Re: Objection to MP08_0244 MOD 1 Modification Request for Mixed Used Development at 23-37 Lindfield Avenue and 11 Havilah Lane, Lindfield

As a resident of Lindfield, I/we wish to lodge an objection against the proposed Modification of the subject development based on the following grounds:

ELEVATIONS

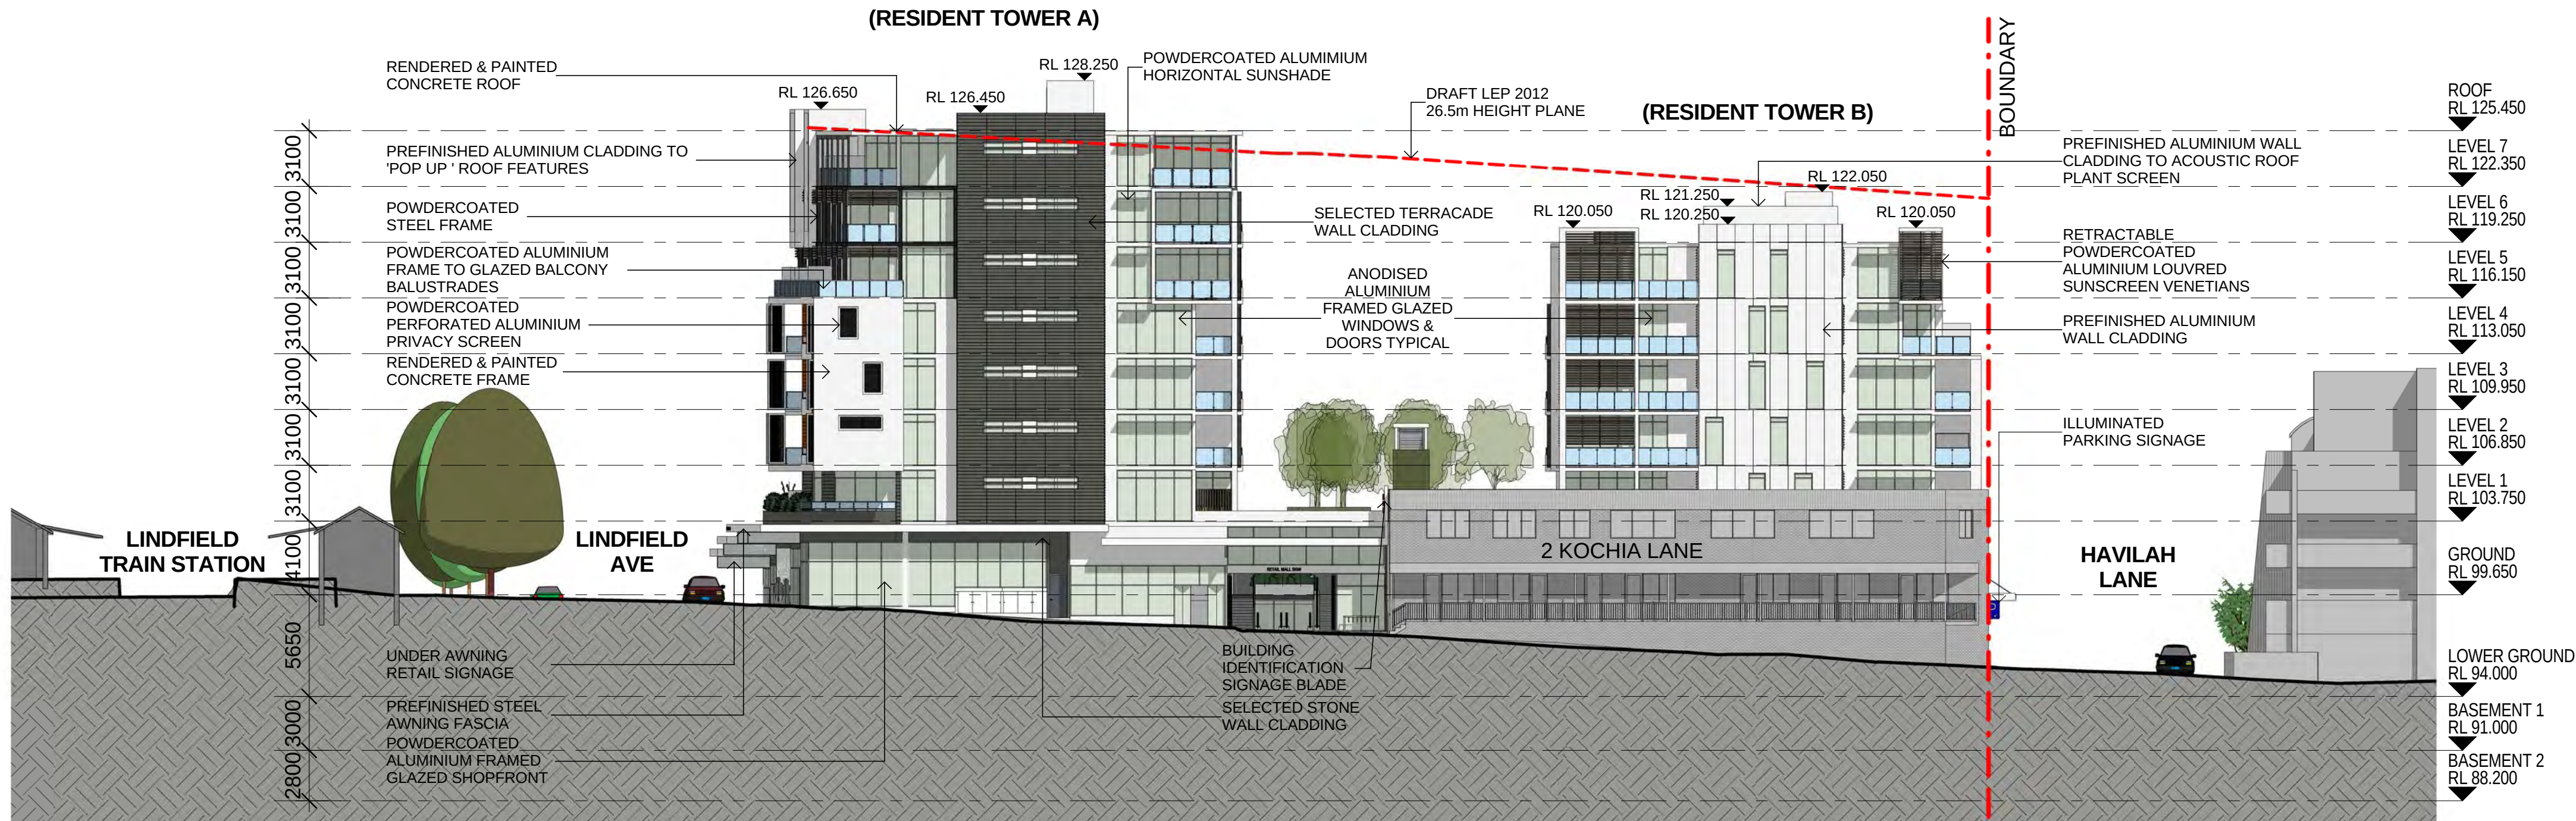
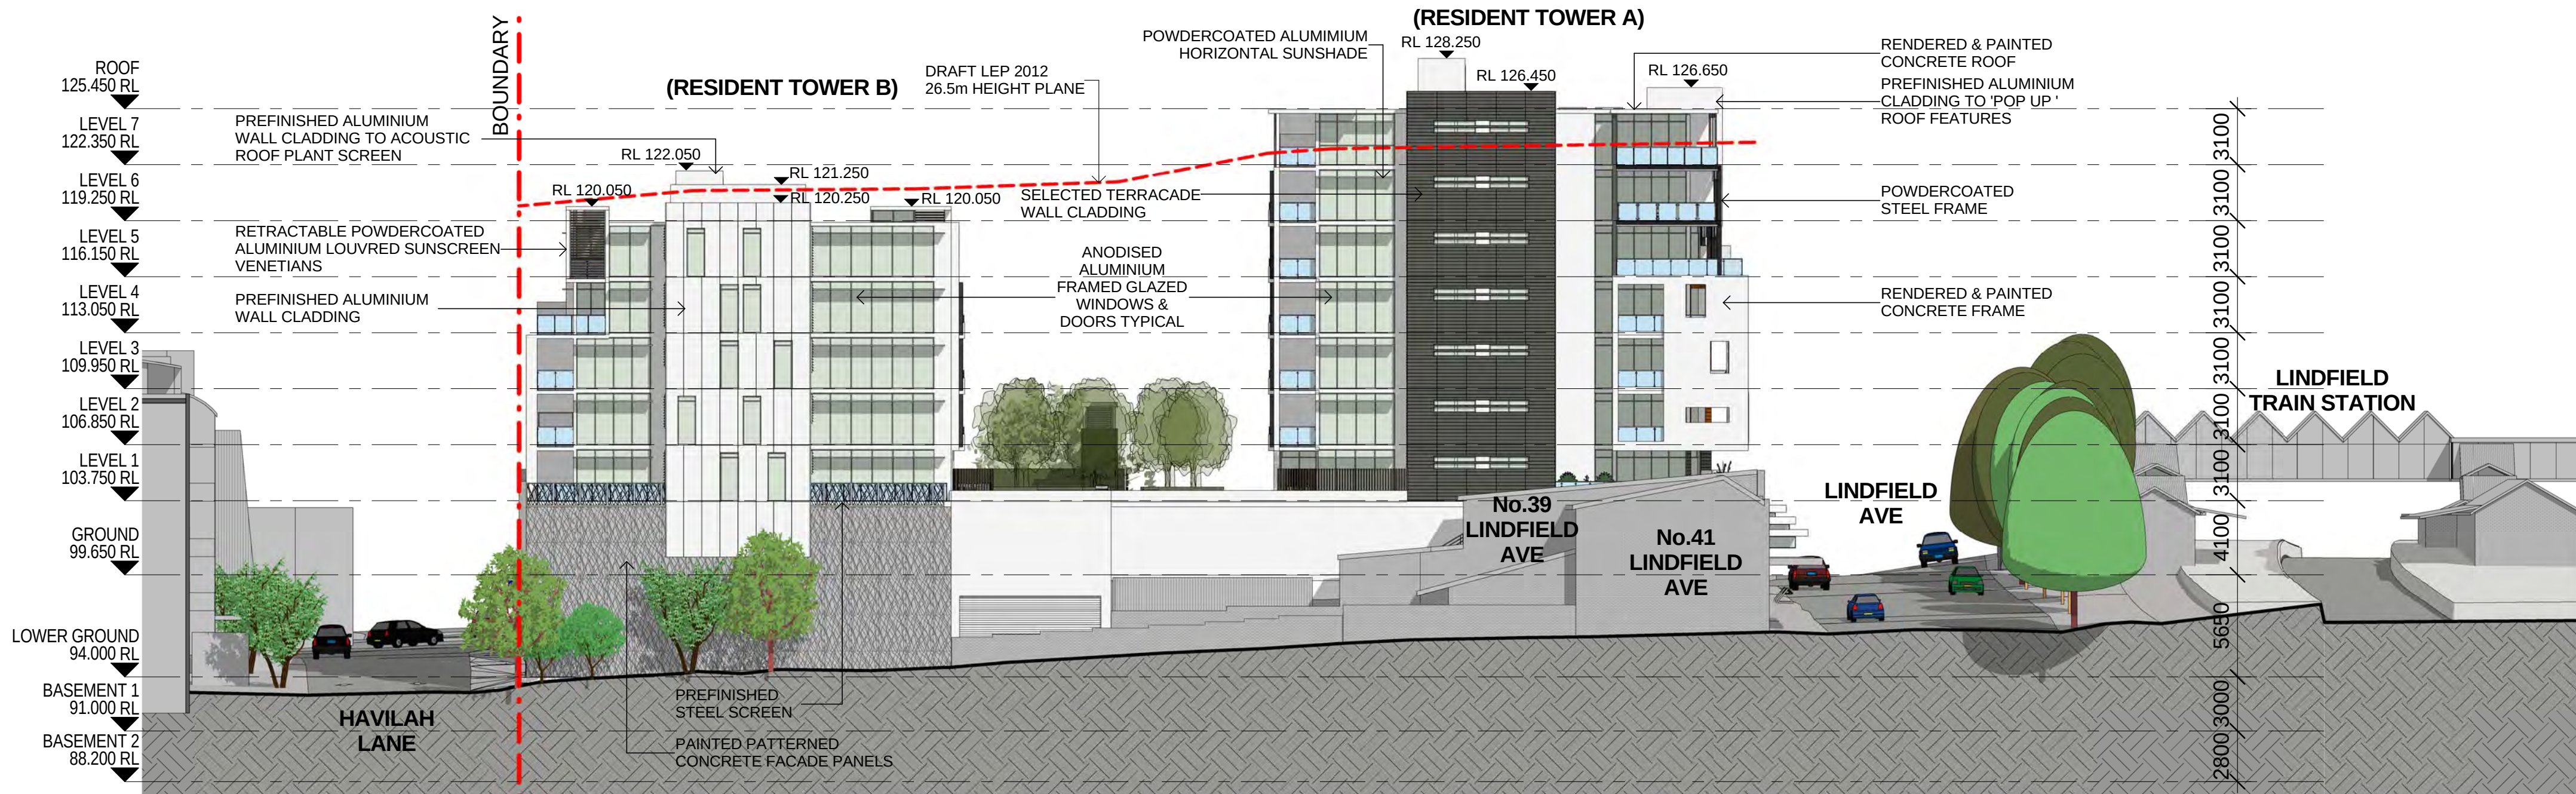
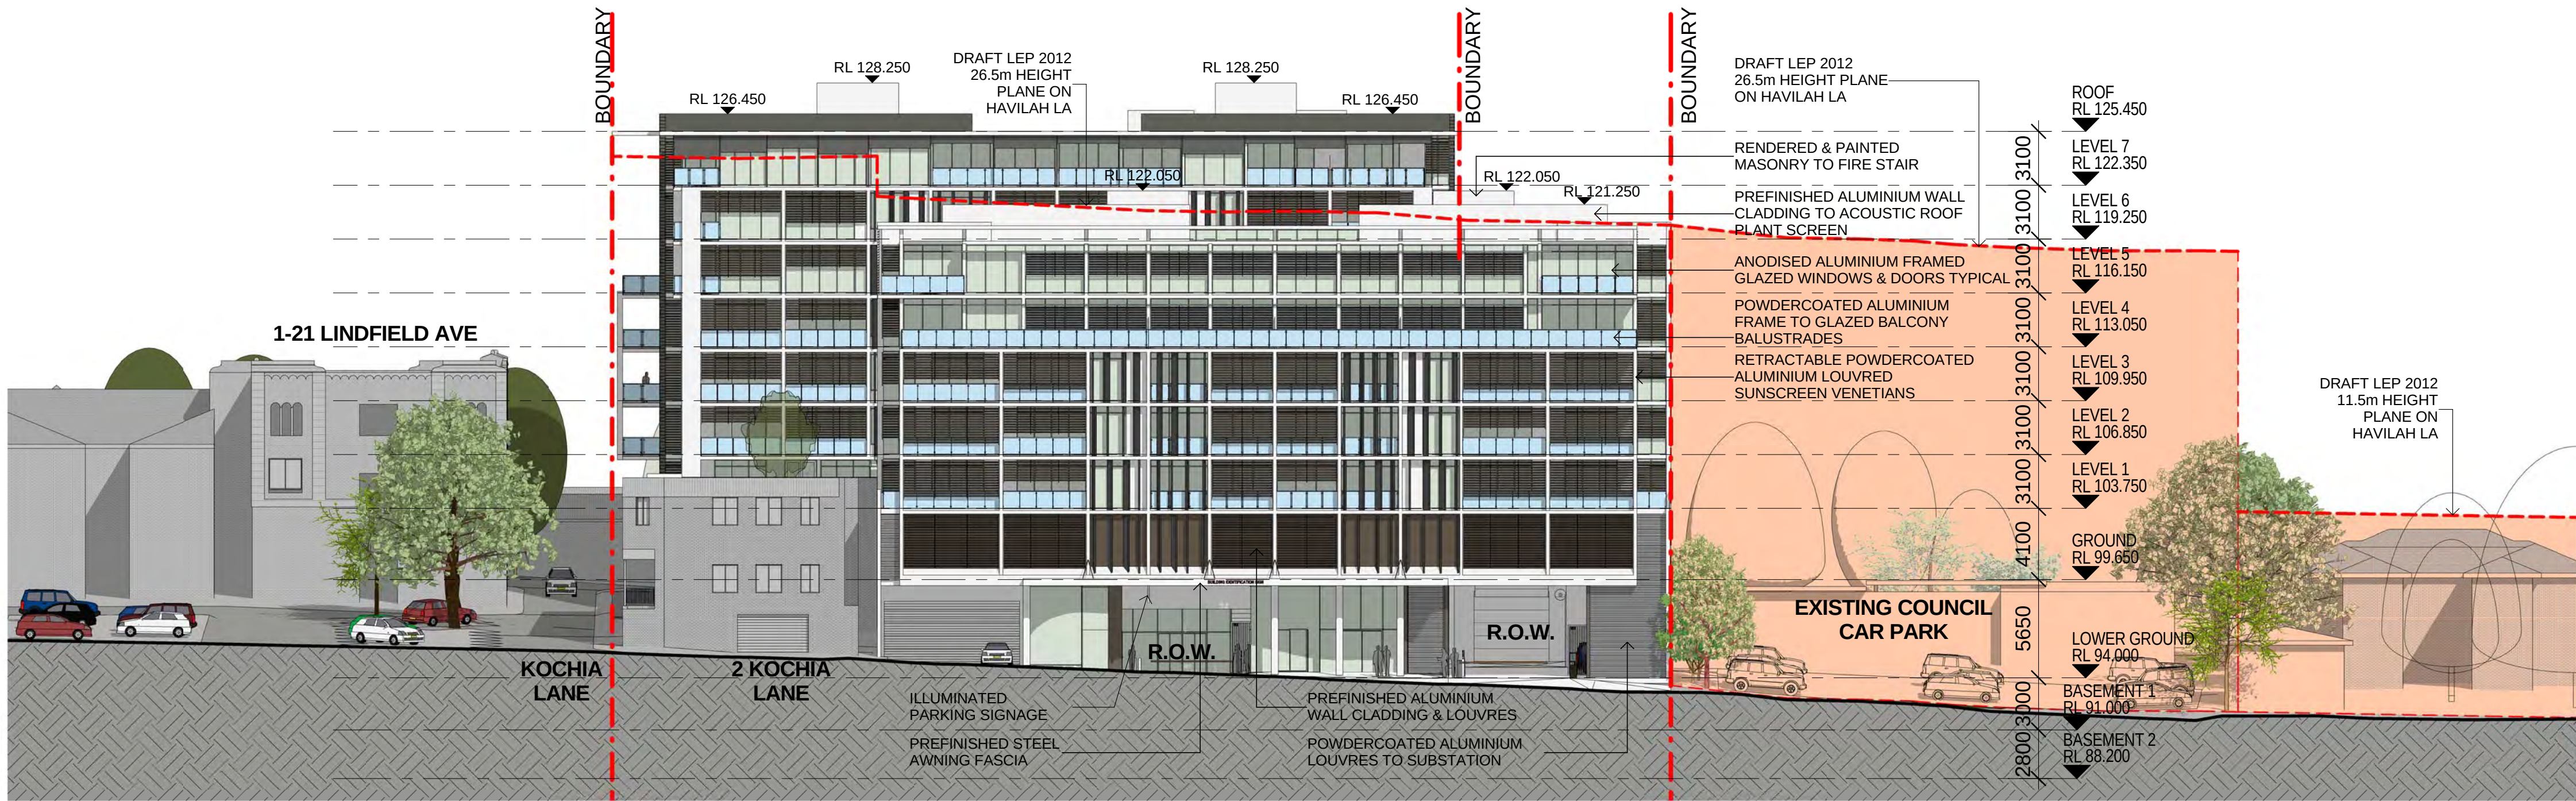
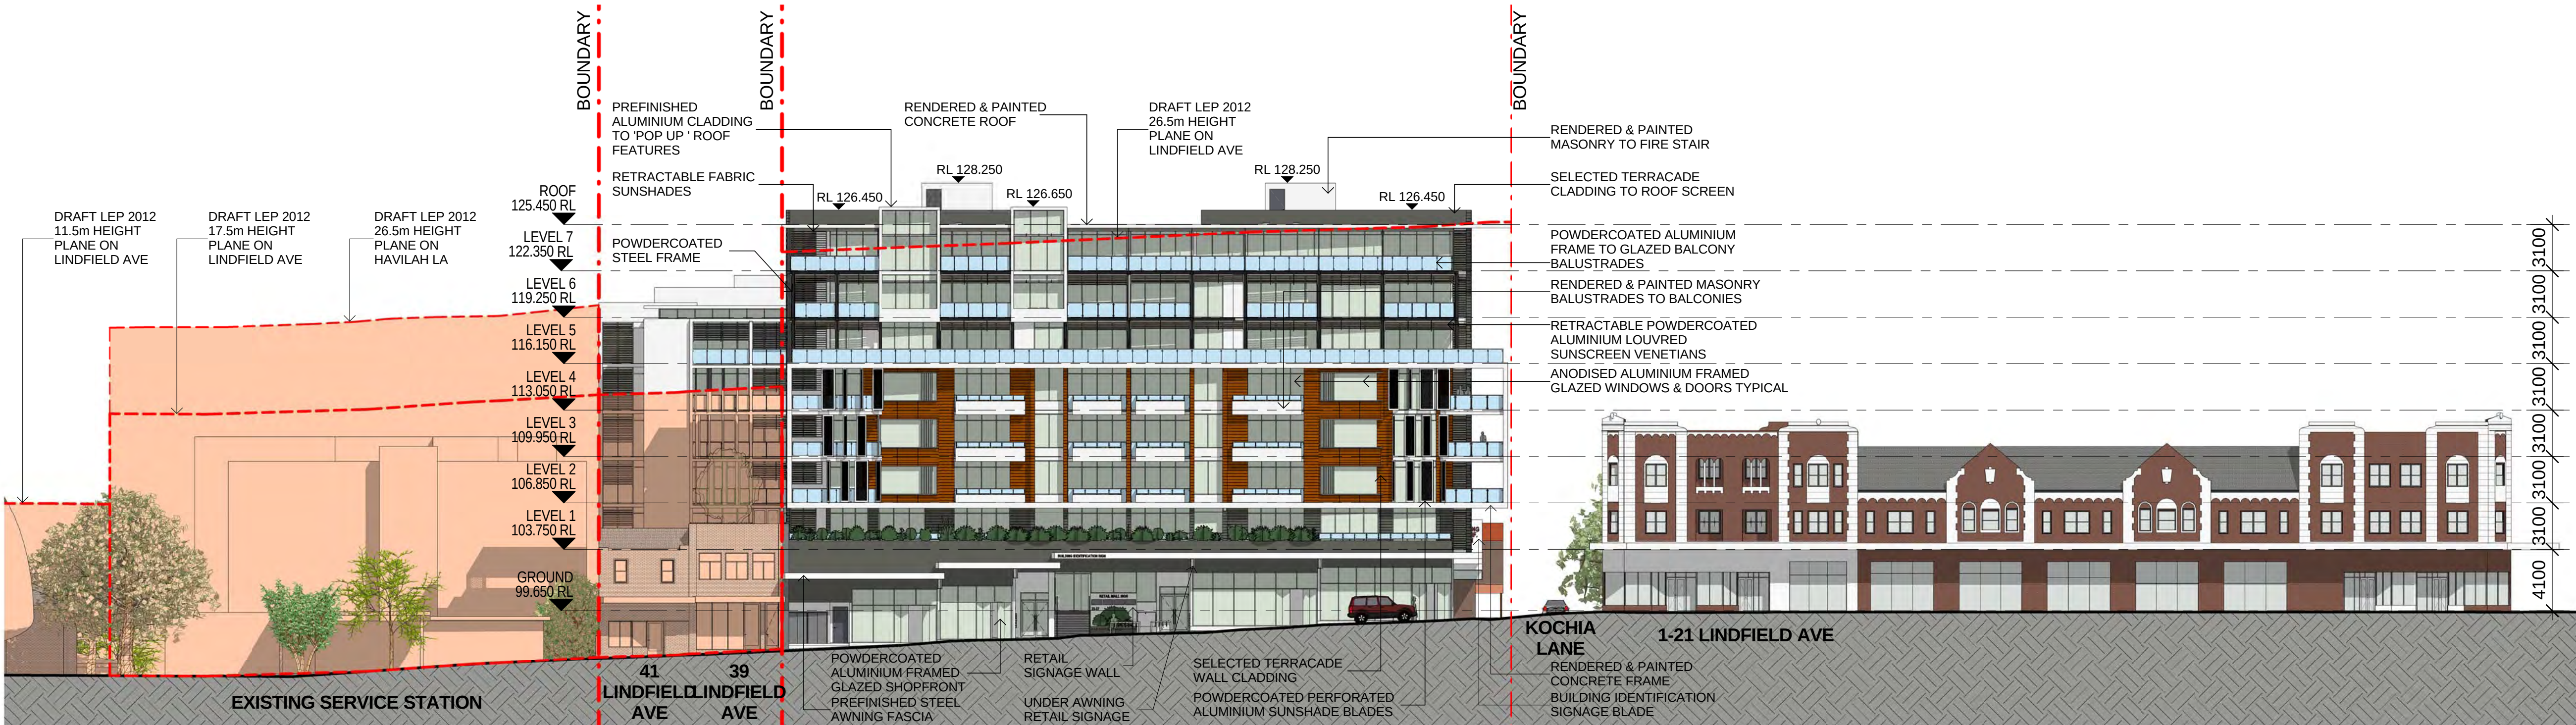
- The increase of an additional storey to both buildings: 8 storeys on Lindfield Avenue and 7 storeys on Havilah Lane creates excessive height and bulk and is out of character with the surrounding buildings, including the heritage listed adjacent building on Lindfield Avenue

- The additional storey (combined with less set back than the approved design) on Havilah Lane now creates privacy concerns for over 40 apartments in the adjacent 8 Havilah Lane, 8 Kochia Lane and 2-8 Millray Street residences
